# Memo

**Re: 3/2019/1131 CHANGE OF USE OF RETAIL PREMISES TO LIVE/WORK UNIT  
WITH RESIDENTIAL FACILITY FOR ONE PERSON – 1 LOWER LANE, LONGRIDGE  
PR3 3SL**

Proposed First Floor Plan

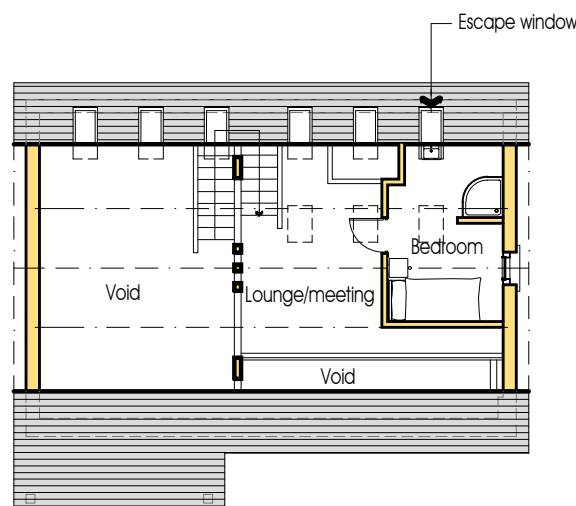
From a development management point of view, I would suggest consideration should be given to the scale of residential accommodation that is to be provided and a judgement as to whether this meets appropriate standards. Amenity space for a residential use is limited.
